Approval of details reserved by condition imposed under ref BN/23/15/PL relating to Condition Nos 5 - surface water drainage, 6 - consent for discharge of any flows to watercourses, 7 - future access & maintenance of watercourses or culverts.

Land Adjacent 4 Lake Lane Barnham PO22 0AD

Arun District Council have decided to **REFUSE details reserved by condition for the following reasons:**

|        | 4 Lake Lane<br>Barnham<br>West Sussex | Surface water<br>drainage plan | Planning    | CB       | CB             |

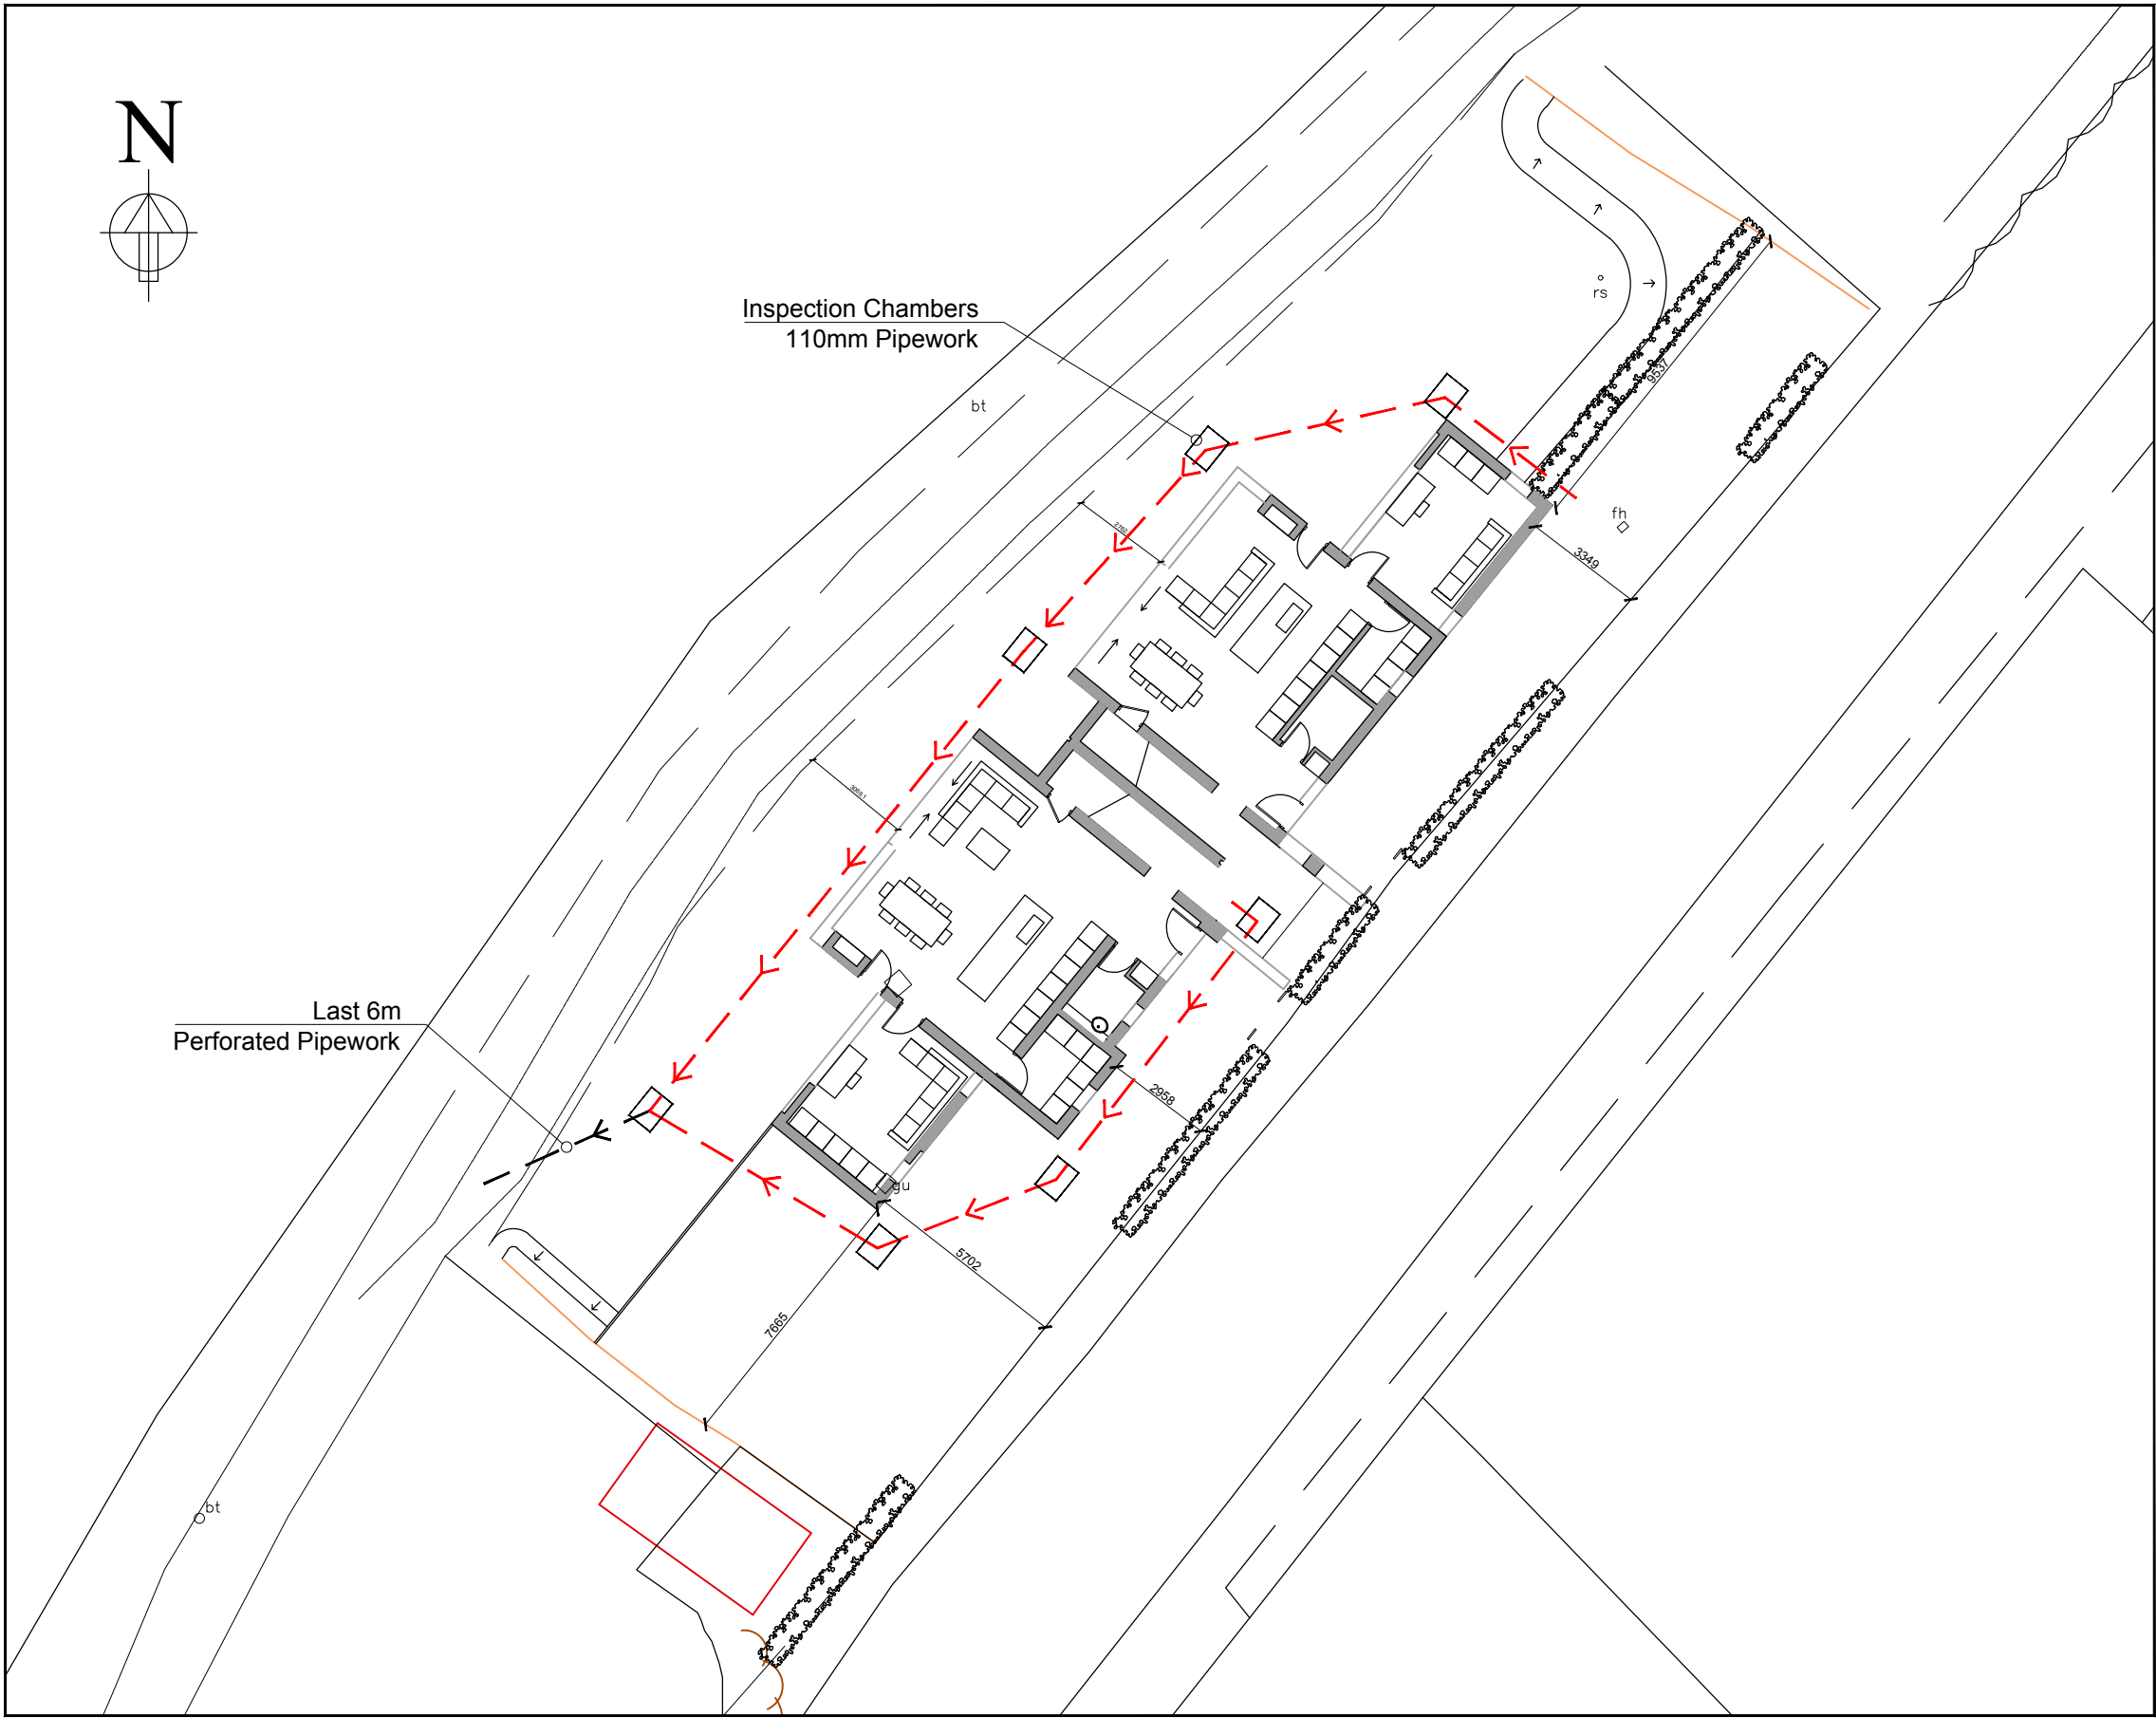
The condition cannot be discharged as the Council's engineers have stated the information submitted is not sufficient to satisfy the Council that the proposed scheme is adequate to effectively drain the site.

The development shall not proceed until formal consent has been approved in writing from the Lead Local Flood Authority (WSCC) or its agent (ADC) for the discharge of any flows to watercourses, or the culverting, diversion, infilling or obstruction of any watercourse on the site.

Any discharge to a watercourse must be at a rate no greater than the pre-development run off values.
